**Rezoning Transportation Analysis**  
**Petition Number: Insert Zoning Petition #2021-259**  
*General Location Identifier: 07908701, 07908702*

**Revision Log:**

Date	Description
04-28-22	First Review (PDM)

**REZONING PLAN
RZ.01**

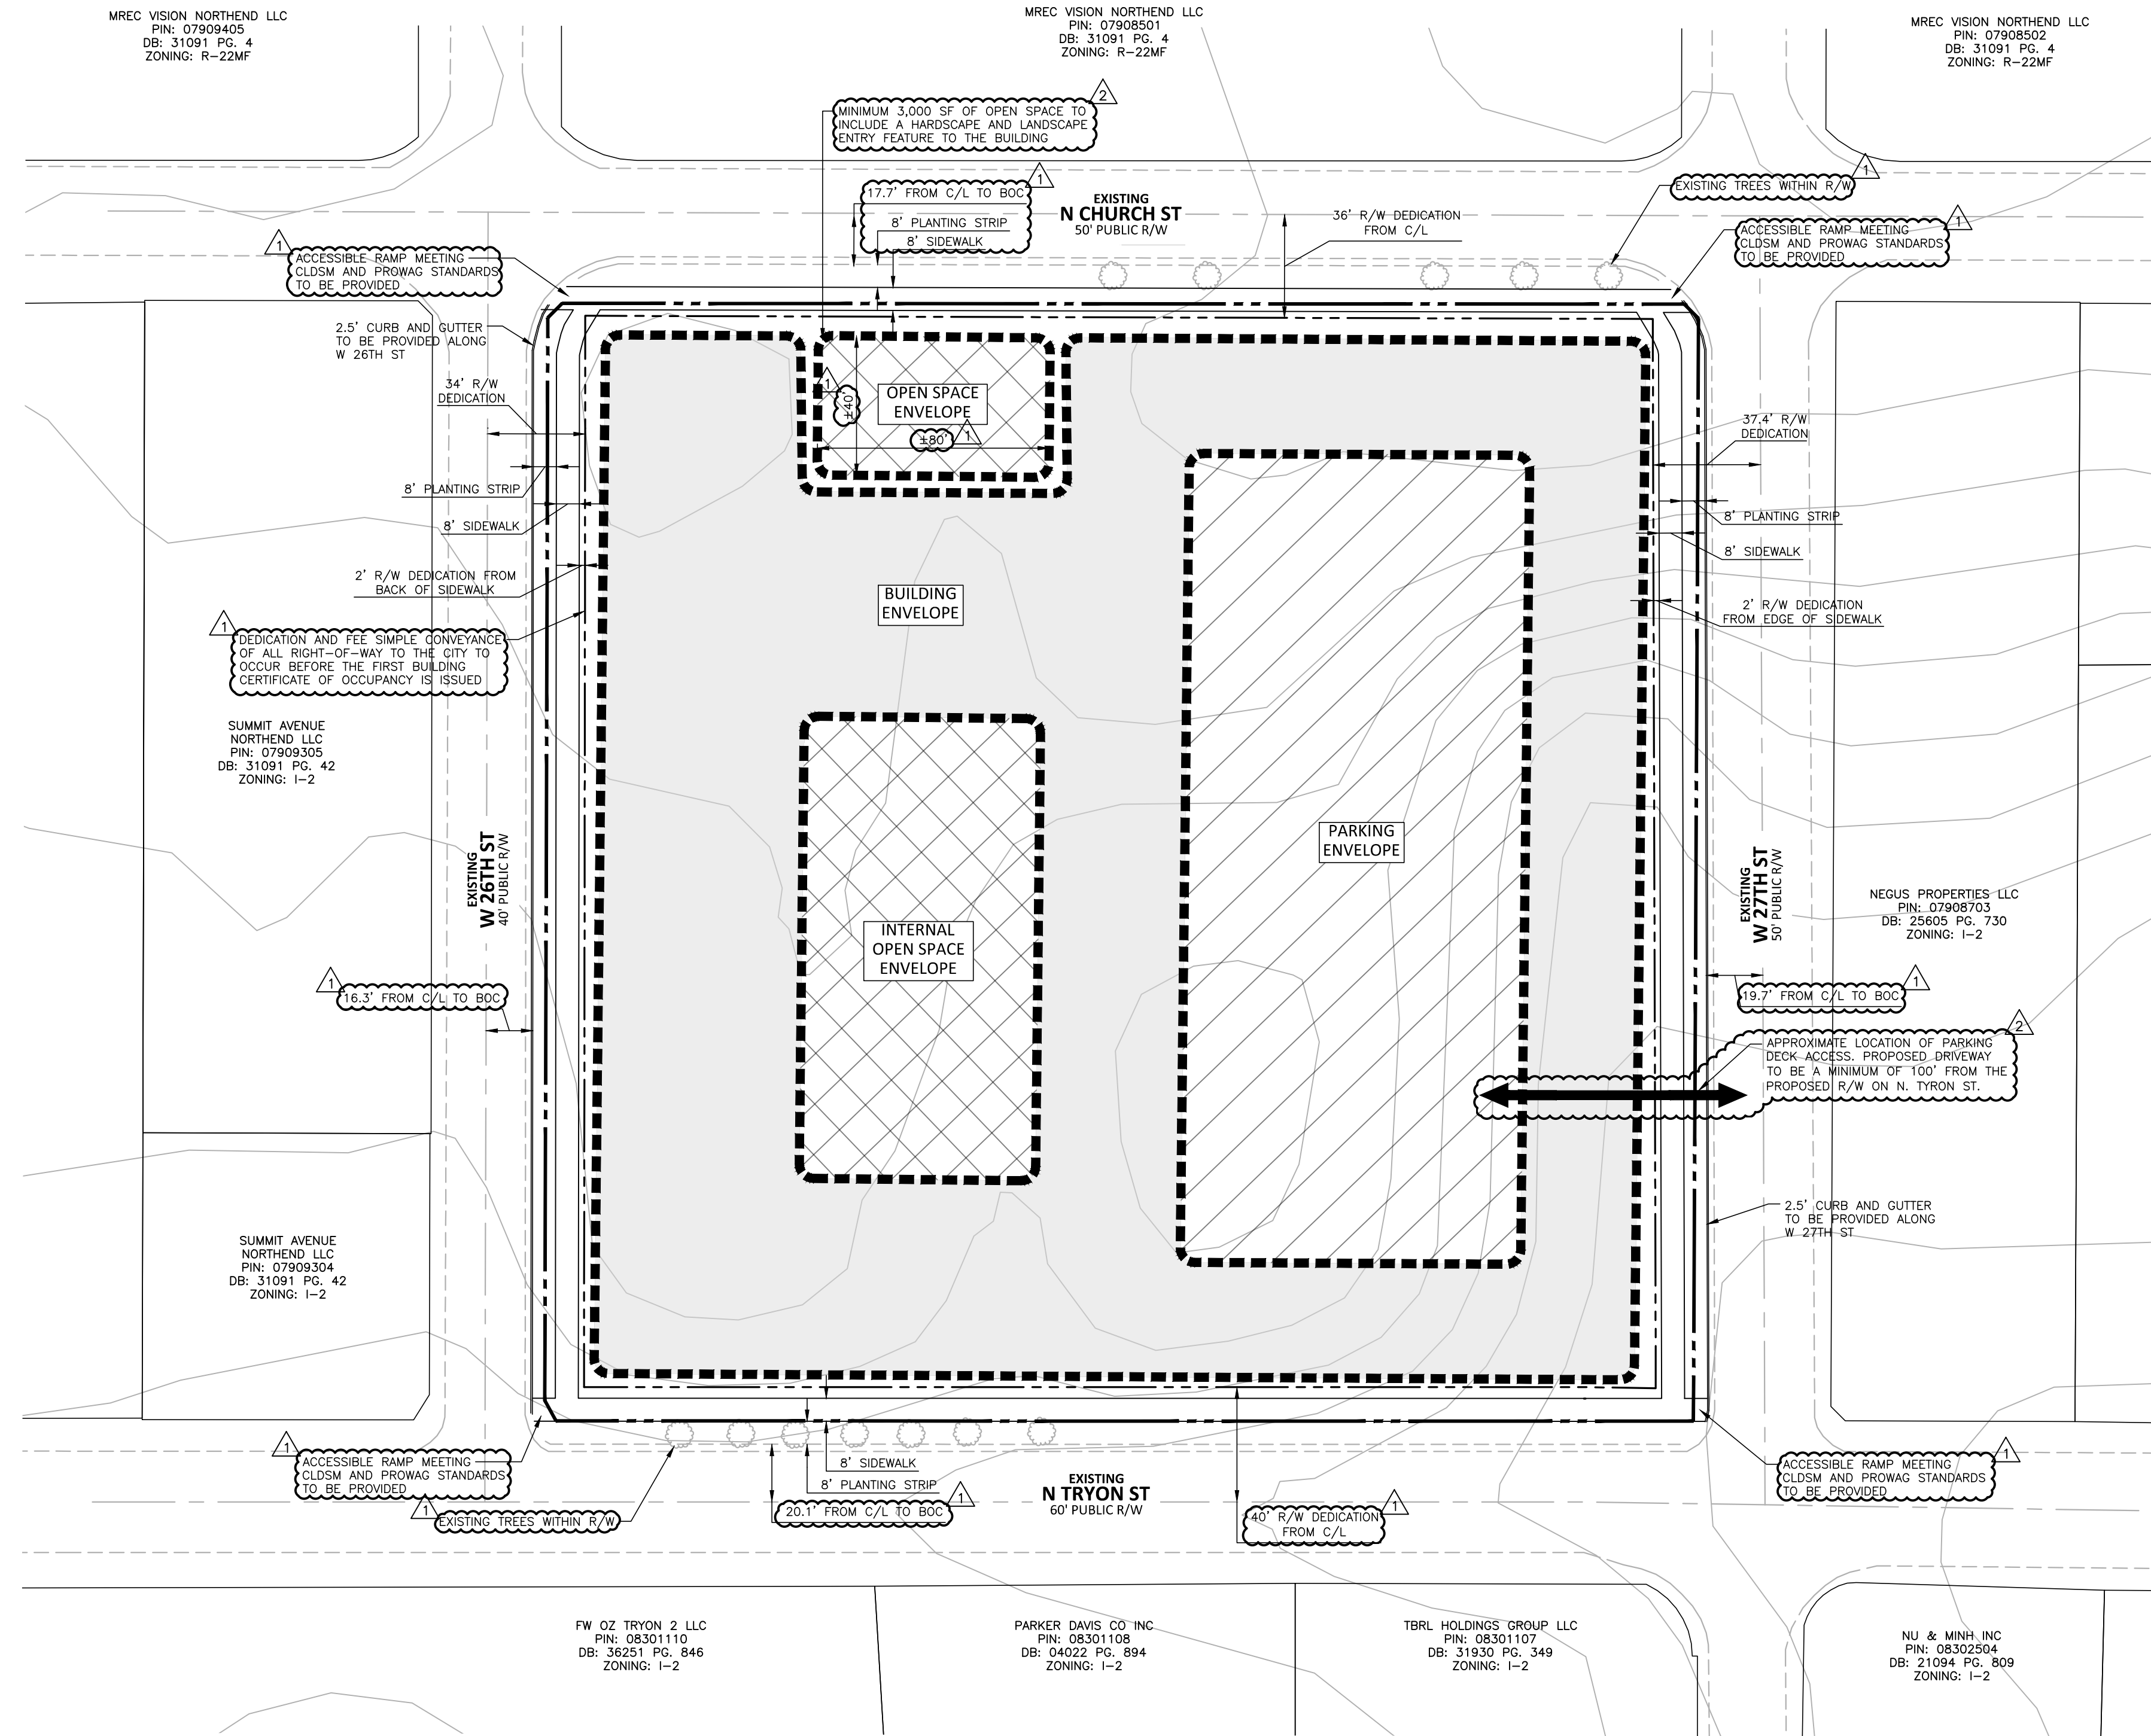
Label and dimension the curb and gutter from the centerline for each road on the site plan.

3. Site plan and conditional note(s) revisions are needed to identify the site access location(s) for the development. CDOT and NCDOT prefer all site access to be located on 26<sup>th</sup> Street or 27<sup>th</sup> Street. Additional comments may be forthcoming based upon the proposed site access location(s) once identified.

4. Revise site plan and conditional note(s) to commit to closing the existing driveways on 27<sup>th</sup> Street if the existing locations will not be utilized by the project. Commit to installing curb and gutter to close the driveway cuts.

5. Revise site plan and conditional note(s) to commit to construct an 8-foot planting strip, and 8-foot sidewalk along North Tryon Street and Church Street. The site plan shall label and dimension both items from the back of curb and gutter and road centerline. The Draft Citywide Streets Map identifies 8-feet as the preferred sidewalk width, because there are on-street bike facilities on each roadway.

6. Revise site plan and conditional note(s) to commit to dedicate 40-feet of right-of-way from North Tryon Street centerline. The site plan shall label and dimension the right-of-way from the road centerline.
